From: Michael Eastham <Michael.Eastham@arun.gov.uk>
Sent: 03 June 2020 18:10
To: Planning.Responses <Planning.Responses@arun.gov.uk>
Subject: LU/90/20/DOC - PARCELS A2 & B6, Littlehampton - Drainage Drawings

Please upload onto Ocella the email below which is the revised consultation response from **ADC Drainage Engineers** to discharge of condition application **LU/90/20/DOC**.

Subject: RE: 2020-05-15-19163-PARCELS A2 & B6, Littlehampton - Drainage Drawings

From: Clark, Robert [REDACTED]
Sent: 15 May 2020 10:27
To: Michael Eastham <Michael.Eastham@arun.gov.uk>; Paul Cann <Paul.Cann@arun.gov.uk>
Subject: 2020-05-15-19163-PARCELS A2 & B6, Littlehampton - Drainage Drawings

Hydro-Brake Control Chamber HB2

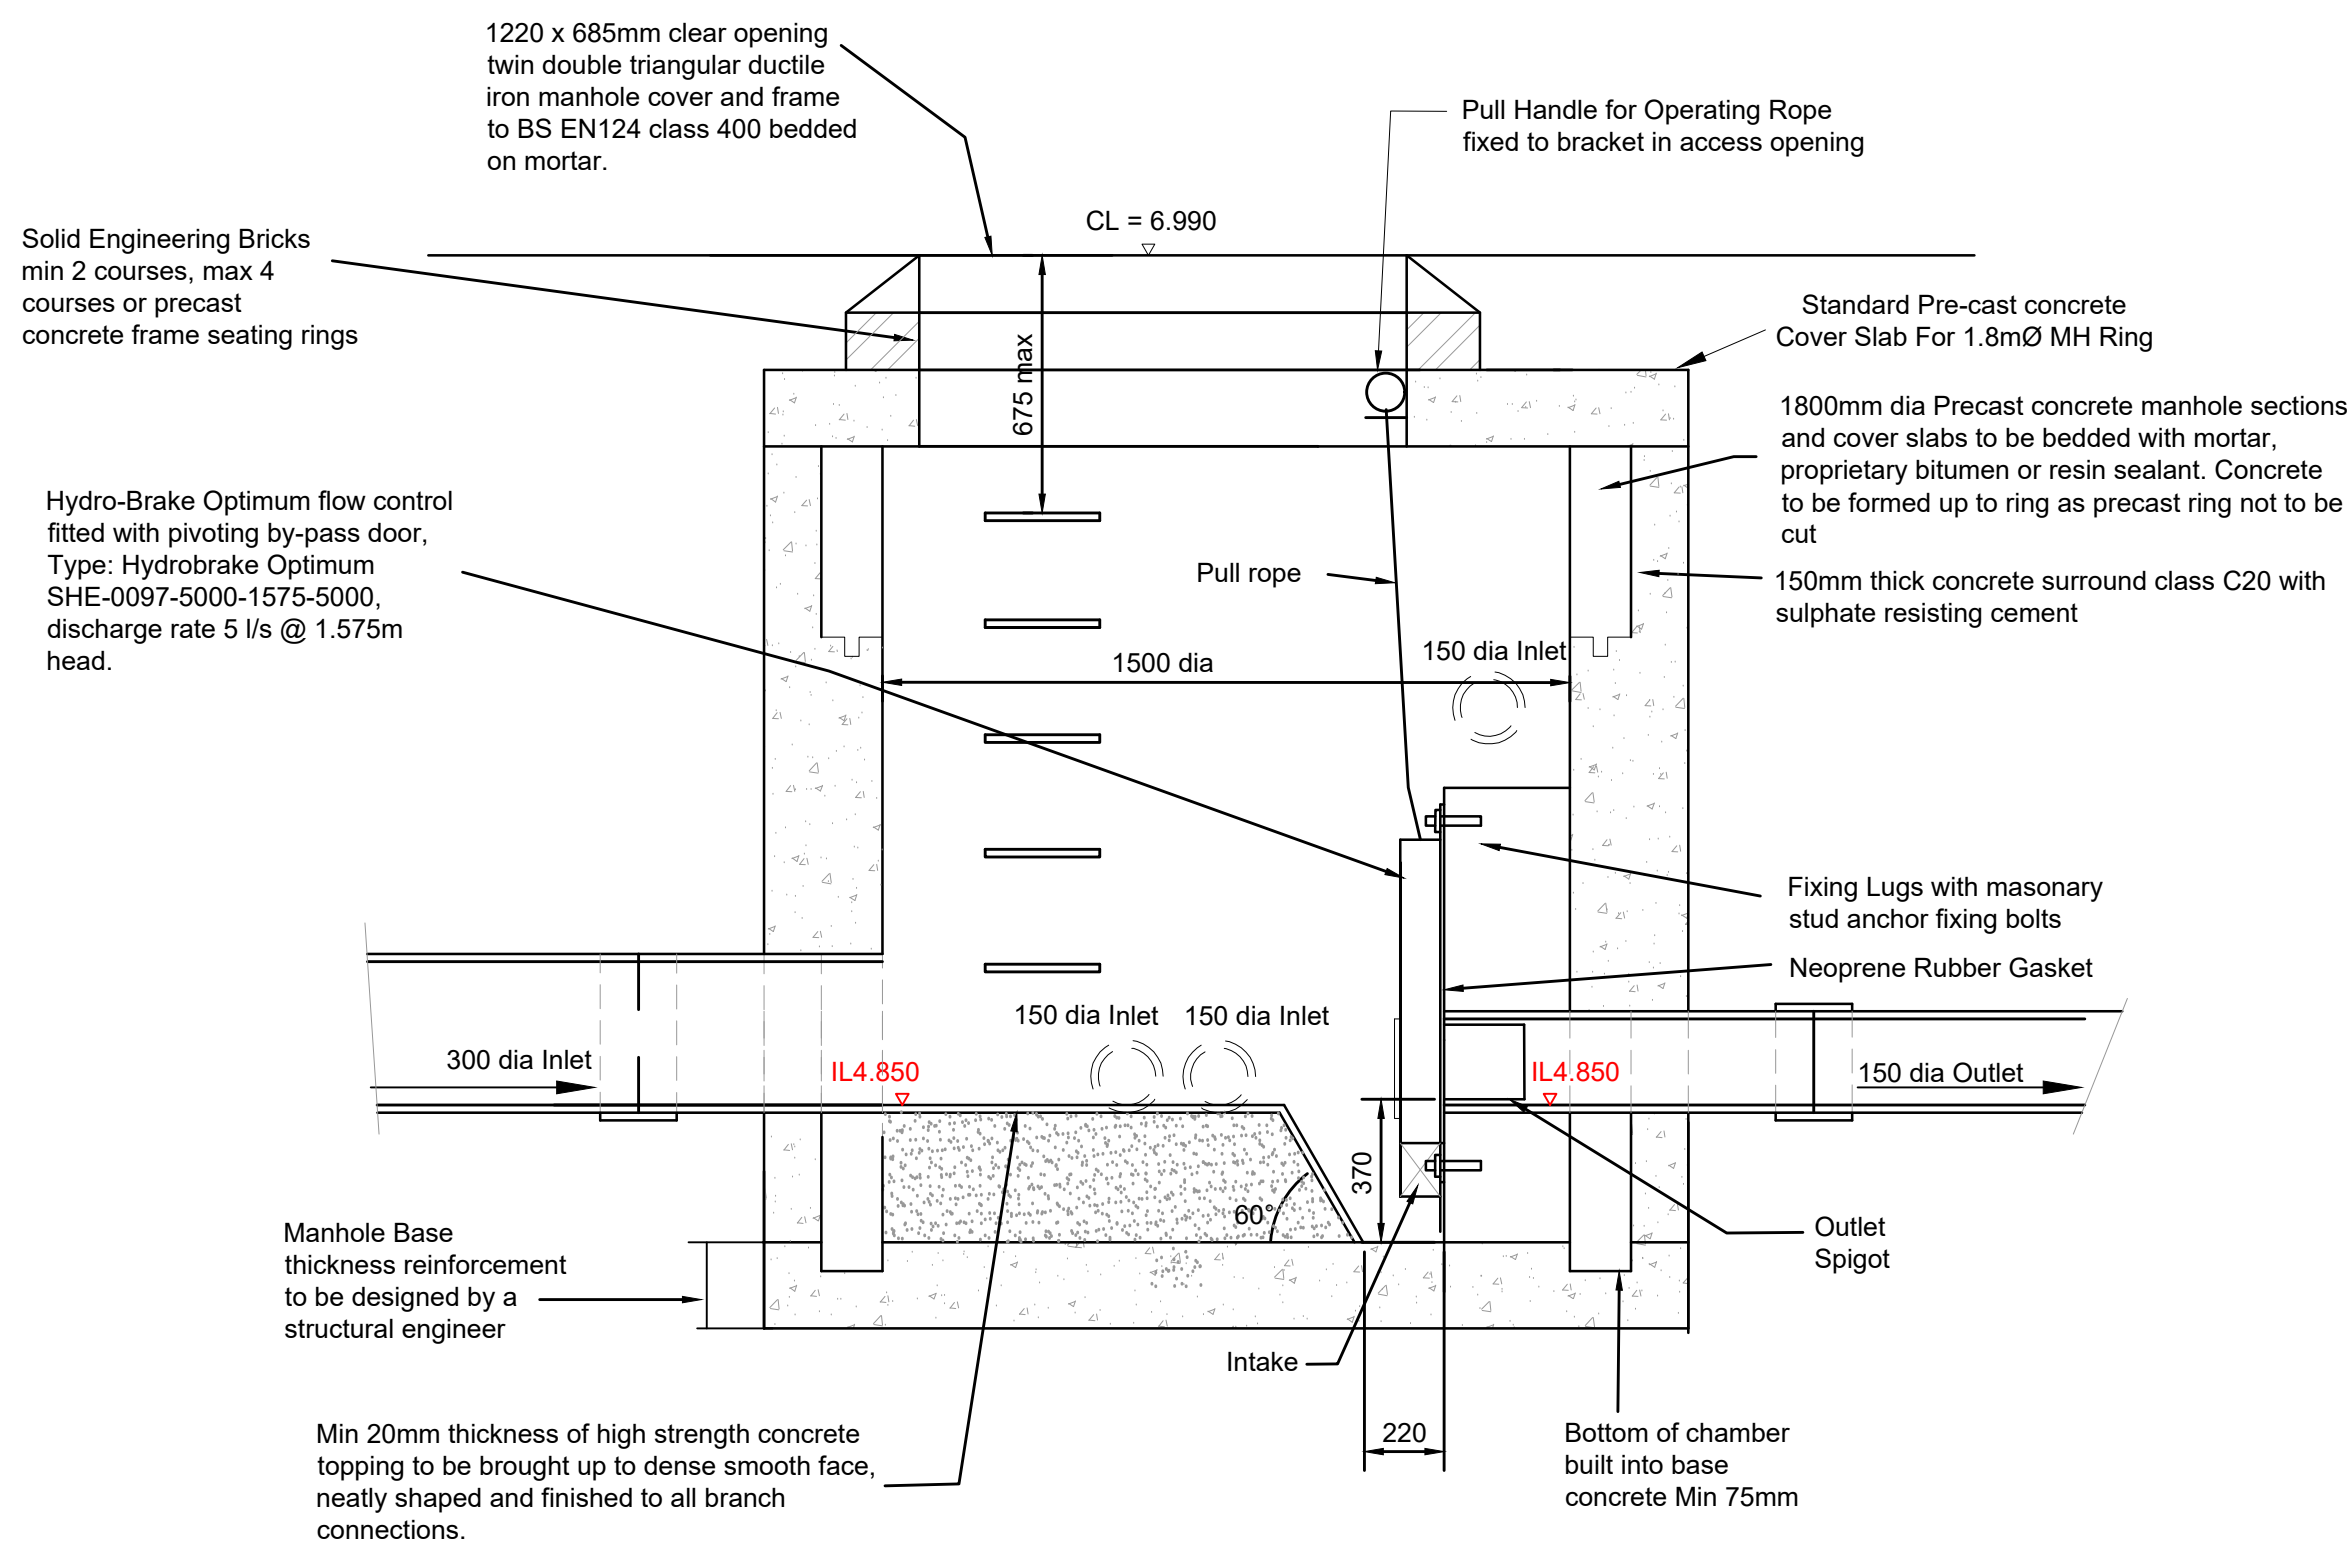
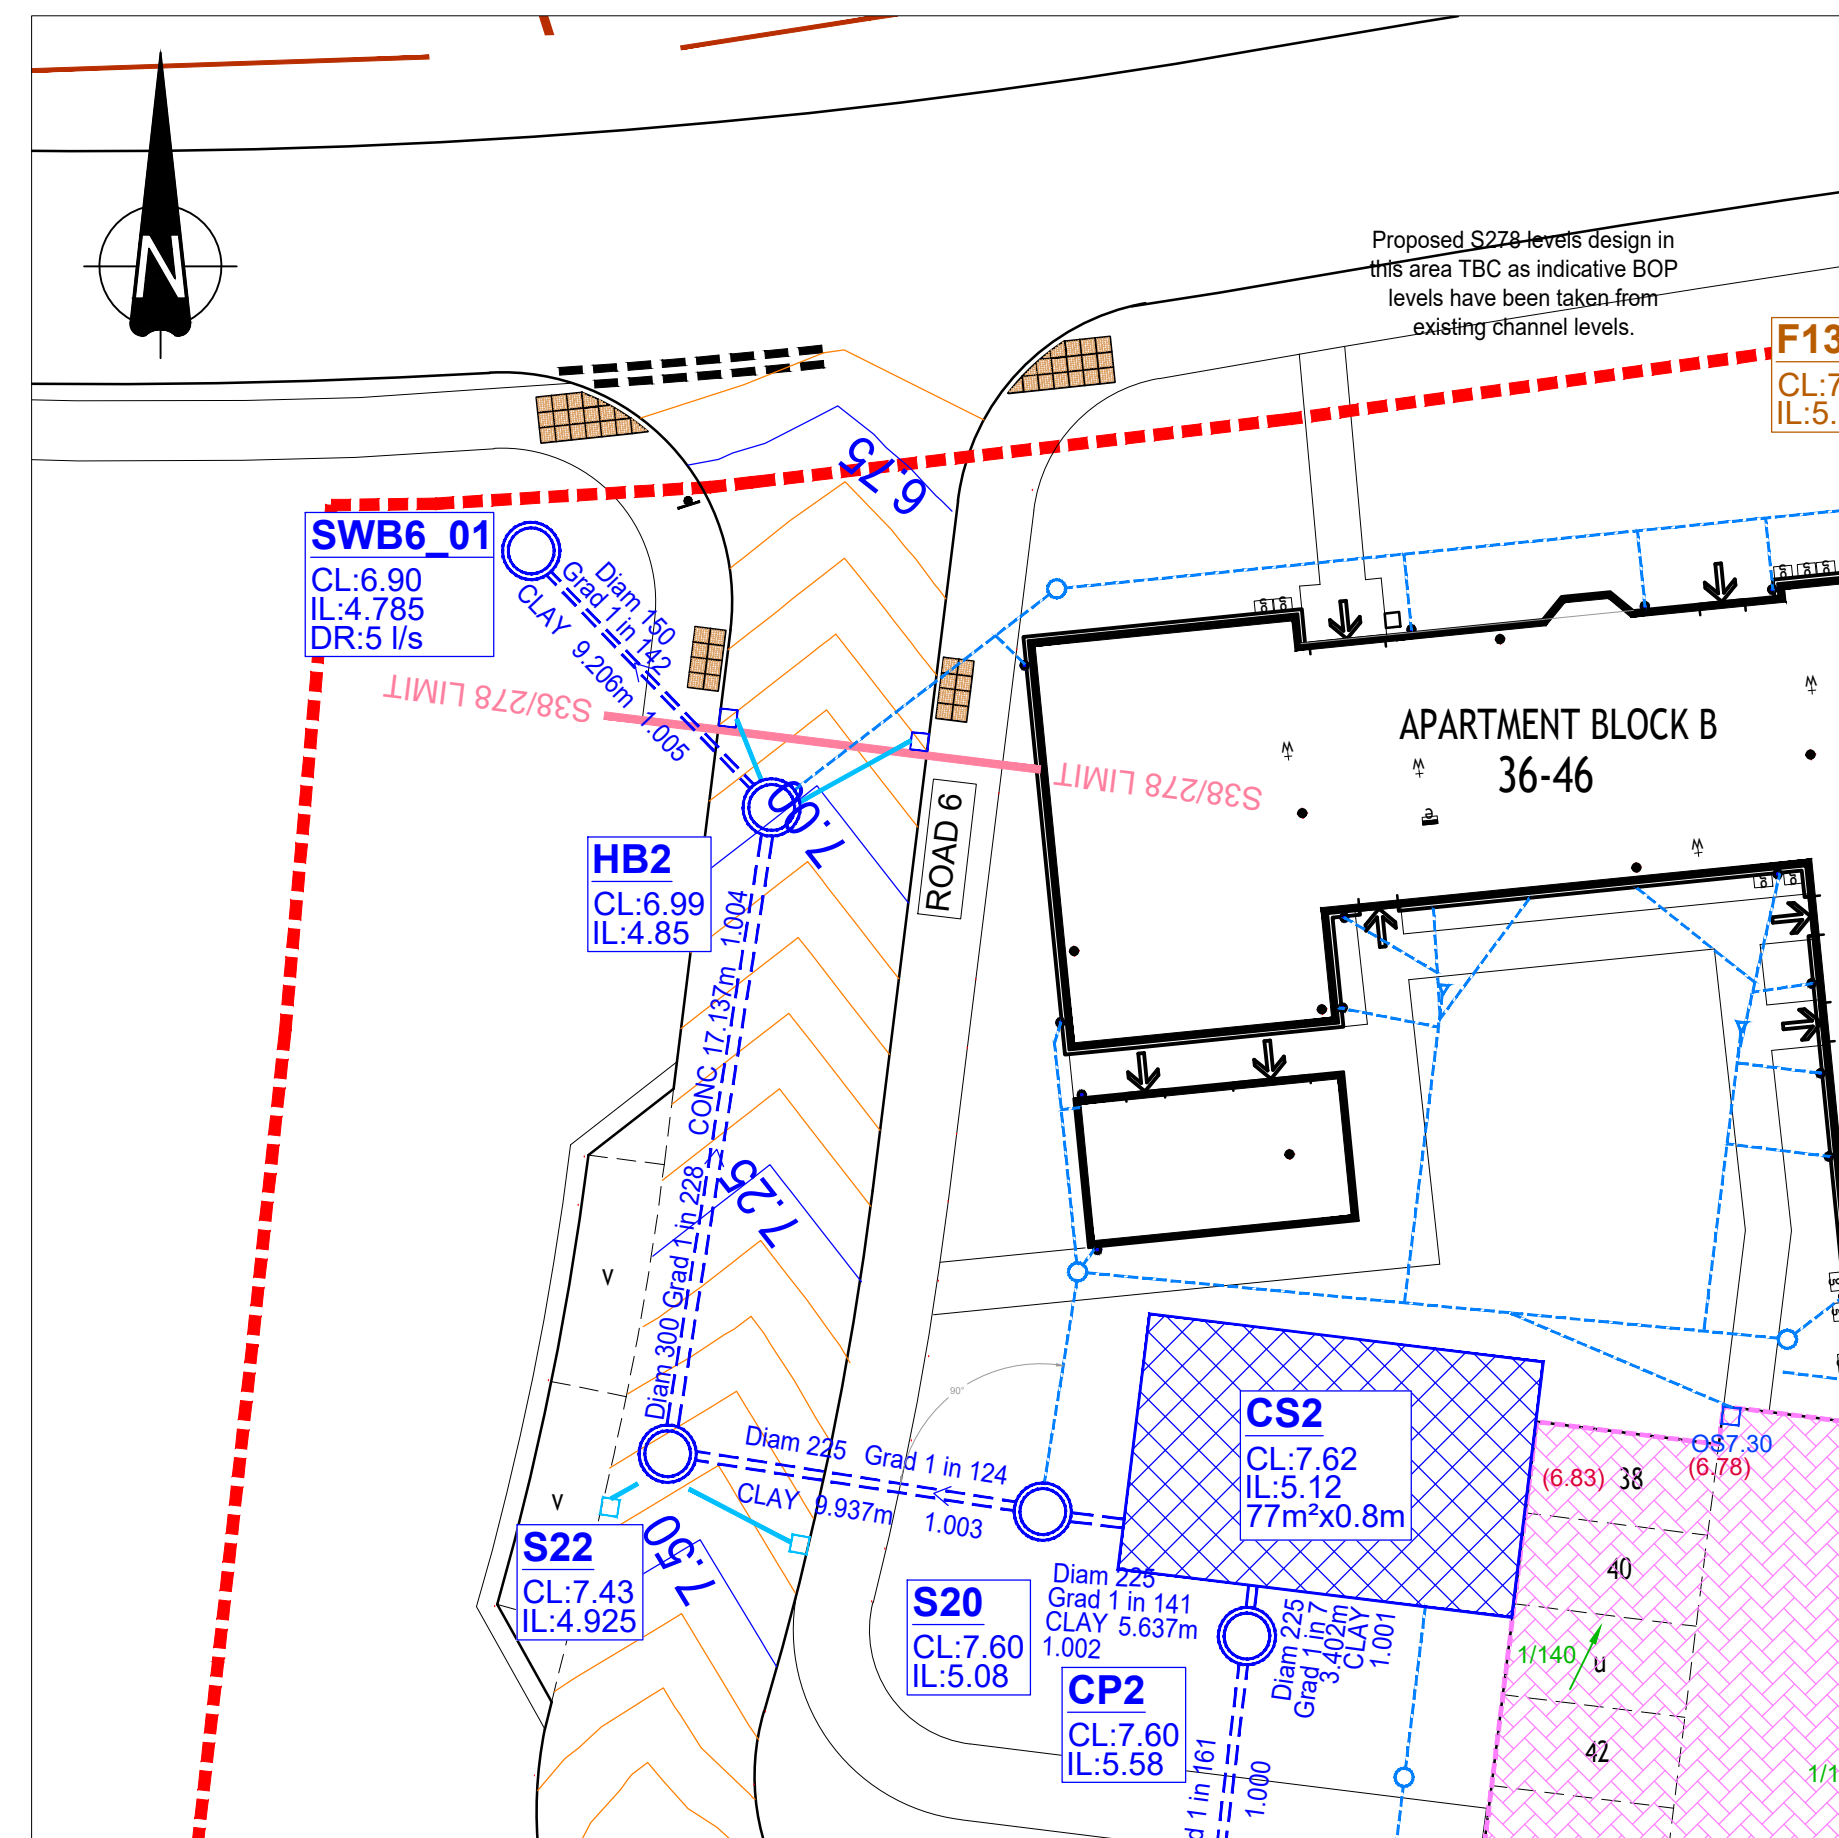
5. Hydrobrake chamber HB02 construction detail – plan view shows incoming 900mm pipe as opposed to 300mm and 1.8m dia rings as opposed to 1.5 dia. Incoming 150mm connections to connect soffit to soffit with 300mm pipe. The gully that is connecting against flow and above hydrobrake is not ideal but willing to accept it in this instance (Section A-A shows it in a different location to the plan view?) *ok*
